PLANNING APPLICATION REPORT**REF NO:** AW/143/08/**LOCATION:** 15 Waters Edge
Aldwick**PROPOSAL:** Proposed extension to music room and lift shaft to first floor - resubmission following refused application AW/83/08/**SITE AND SURROUNDINGS**

south 1/100

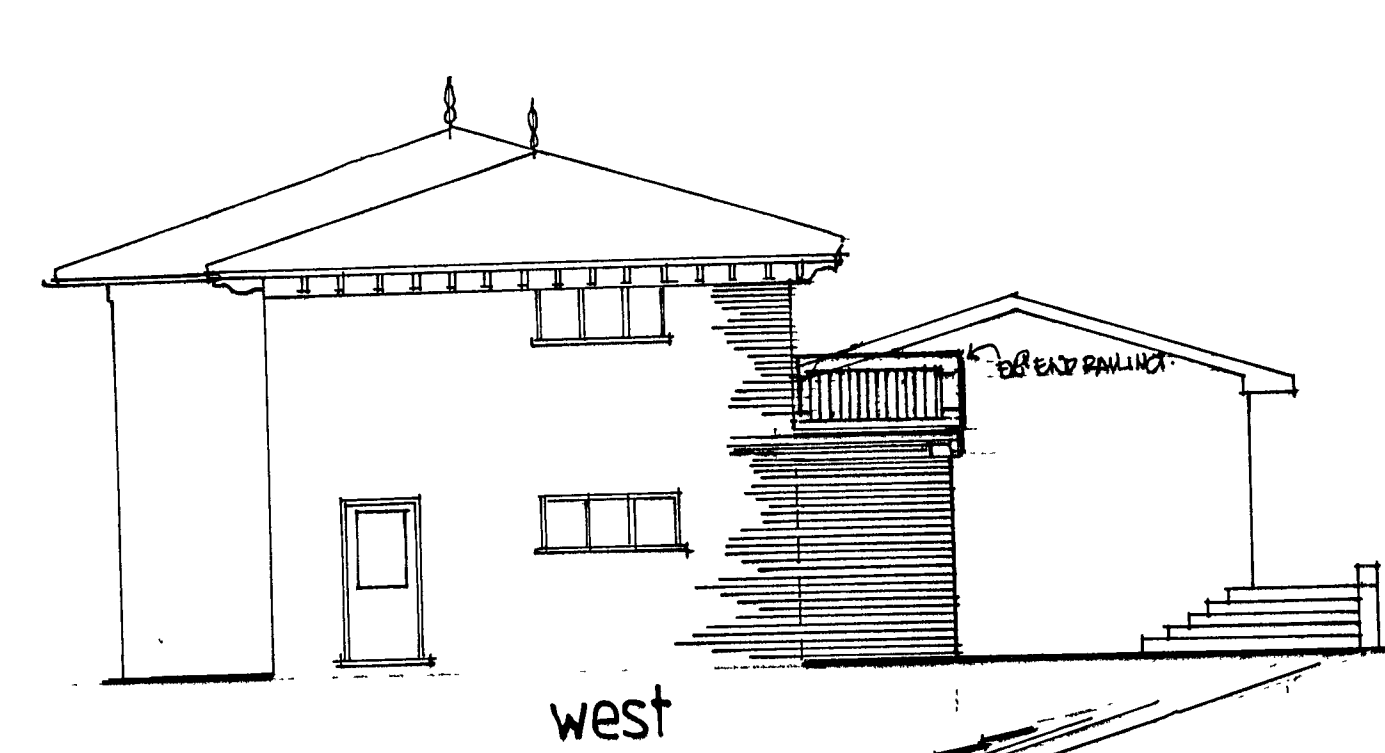
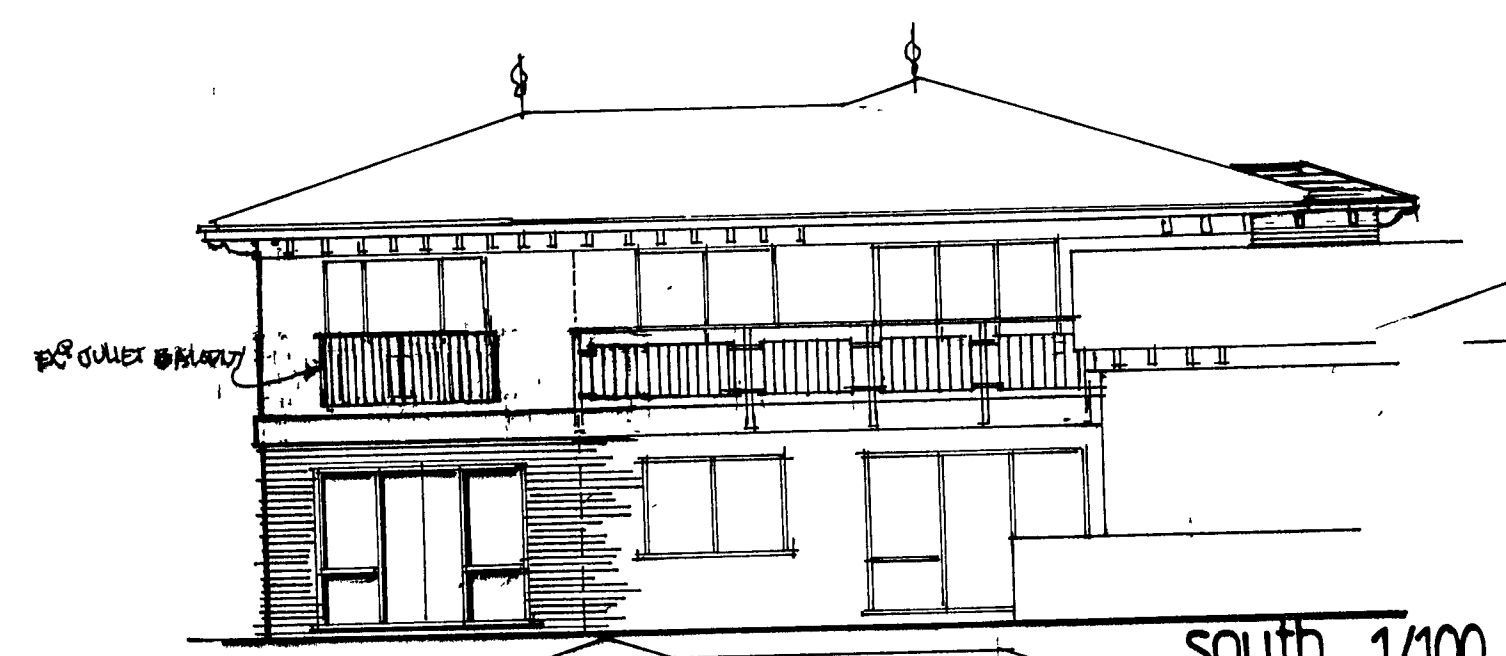
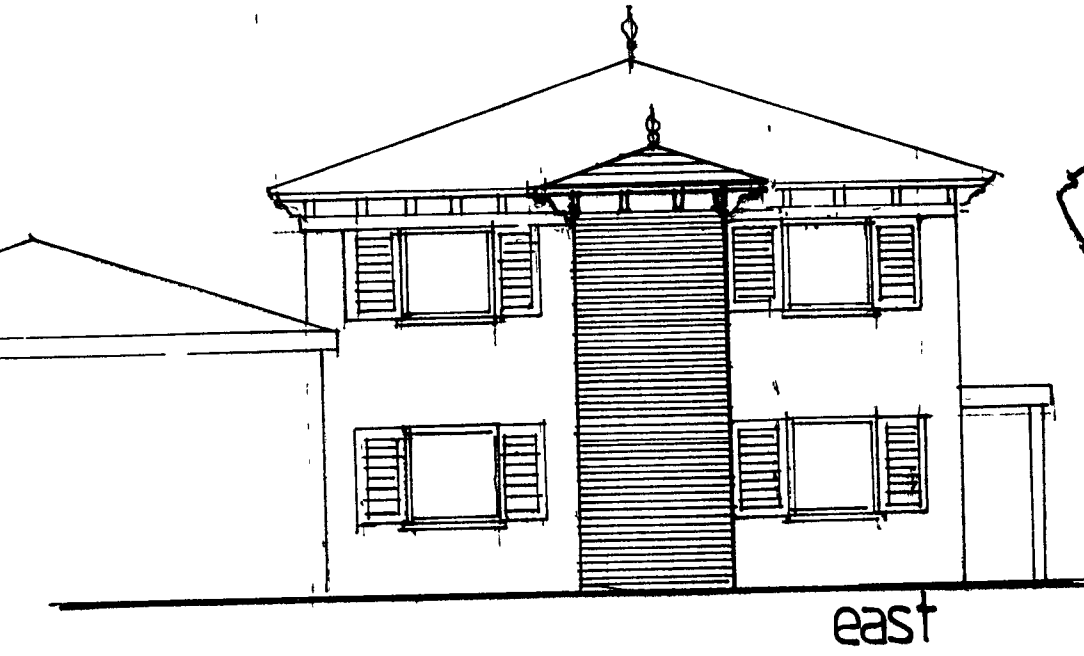
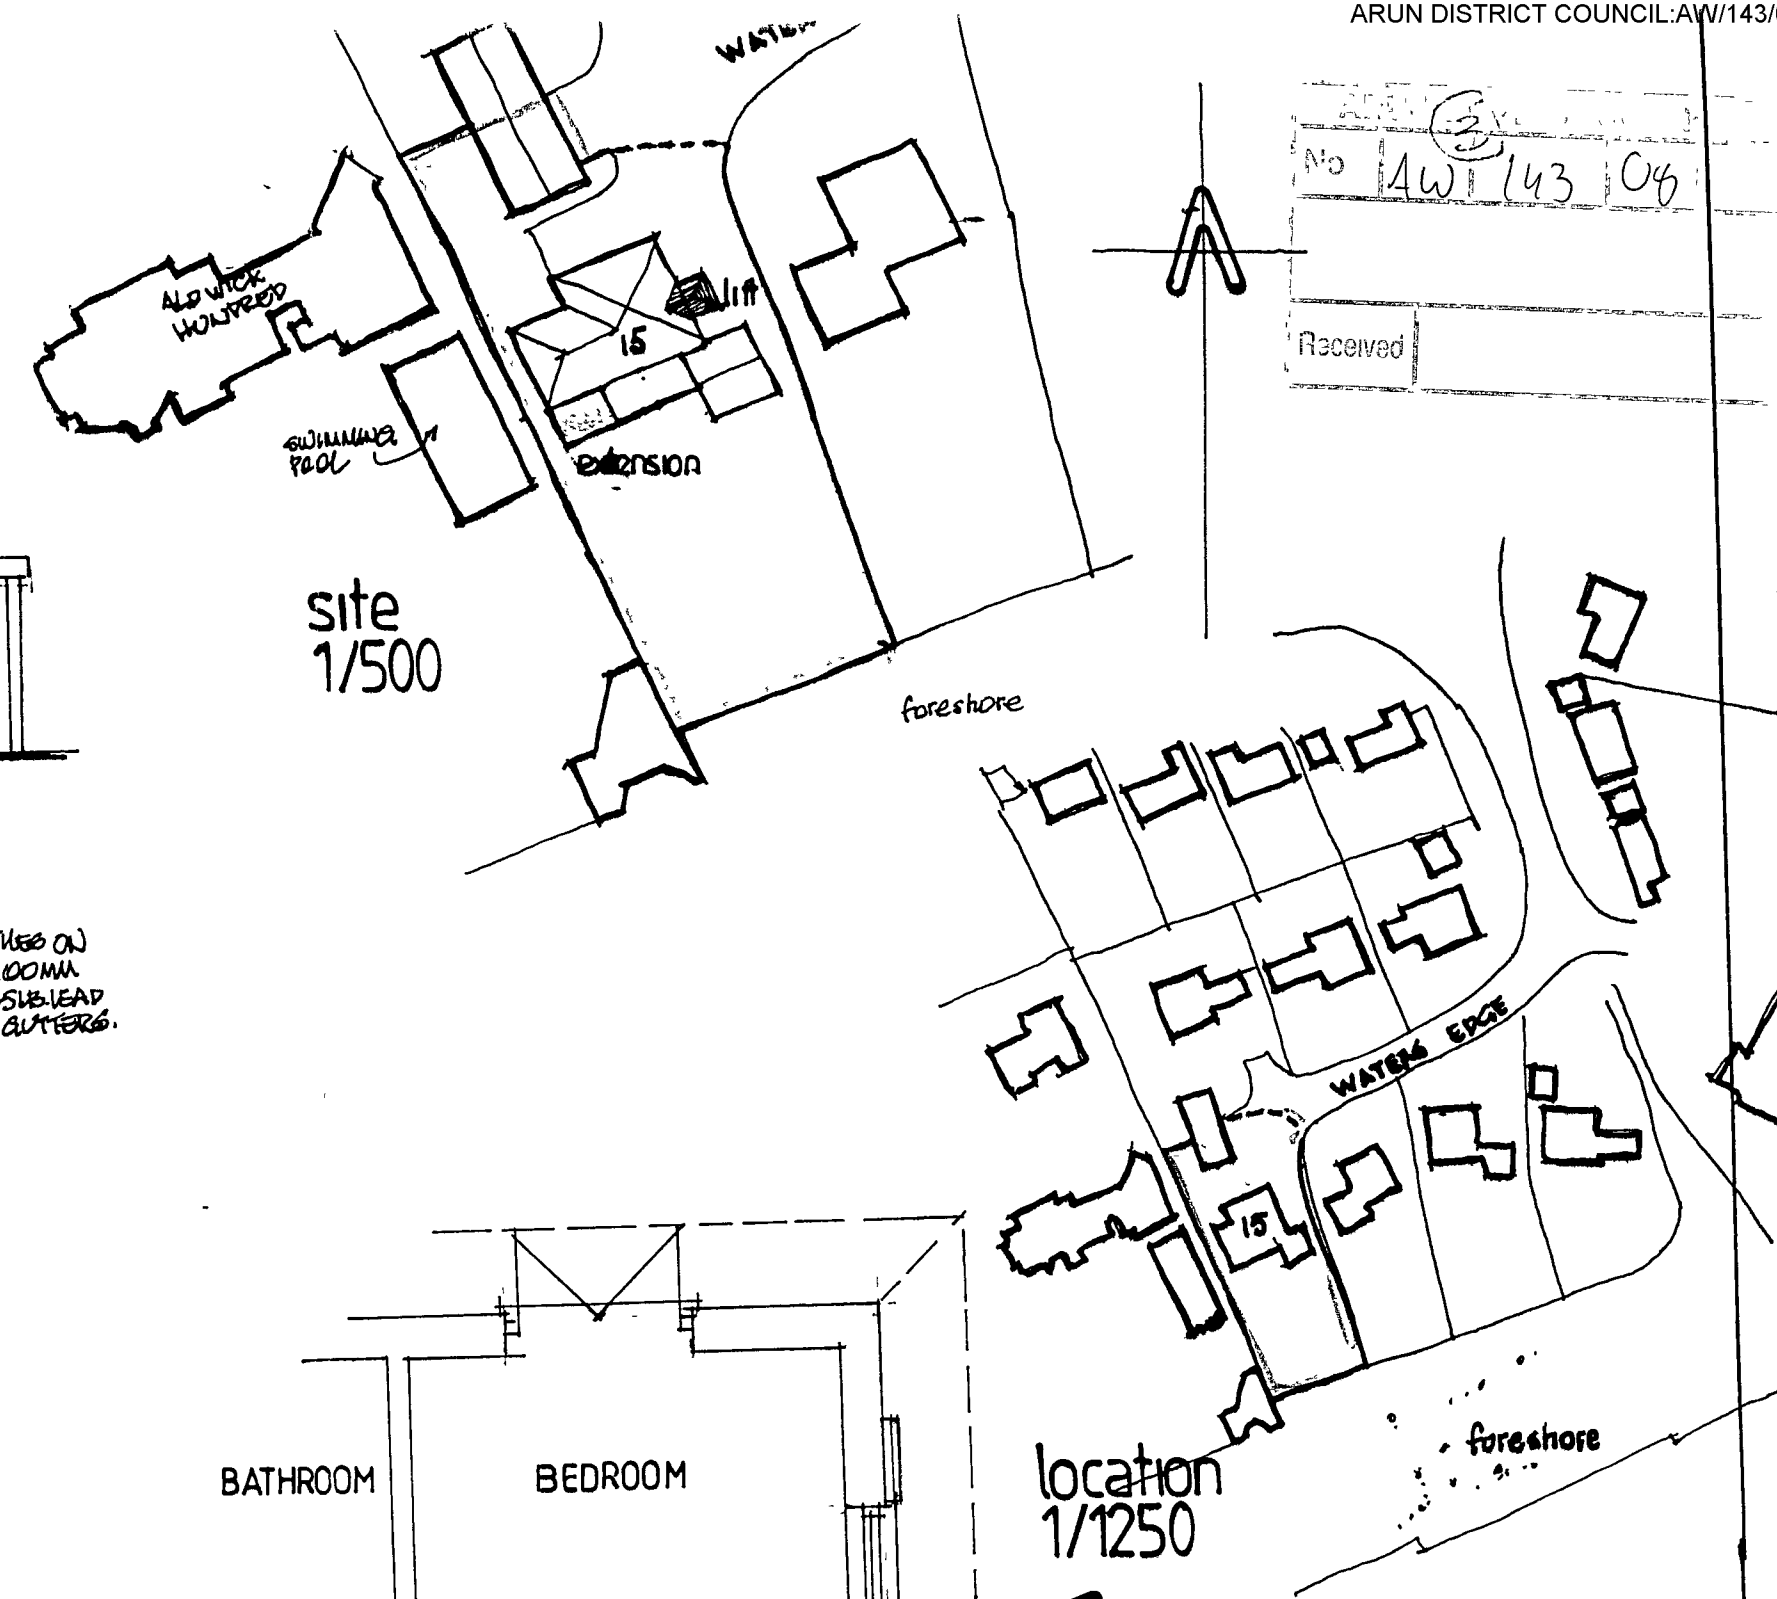
This application is a result of negotiation between planners and the agent following a previous refusal on the site, planning application AW/83/08. That was refused, solely, because the protruding balcony to the ground floor extension was considered to result in an un-neighbourly form of development resulting in unacceptable overlooking and loss of privacy, and likely noise intrusion on neighbouring property to the west. In the current proposal, the protruding balcony element has been omitted and replaced with a Juliet balcony, so the previous reason for refusal has been resolved.

Considering residential amenities, sufficient distance is retained between the extensions and neighbouring properties so as to avoid adverse overbearing and overshadowing effect. No first floor windows exist in the east elevation two-storey extension, and planning condition can ensure the flat roof area of the ground floor extension is not used as a balcony/amenity area. The Juliet balcony does not allow for standing space. As such, overlooking onto neighbours either side would be oblique, rather than direct, so the proposal is not considered to result in adverse overlooking and loss of privacy onto the occupiers of the occupiers of those properties.

- 3 Notwithstanding the provisions of the Town and Country Planning (General Permitted Development) Order 1995, no windows or other openings (other than those shown on the plans hereby approved) shall be formed at first floor and above in the two-storey extension hereby permitted without the prior permission of the Local Planning Authority on an application in that behalf.

- 4 The flat roof area of the single storey extension hereby permitted shall not be used as a balcony, roof garden or similar amenity area without the grant of further specific permission from the Local Planning Authority.
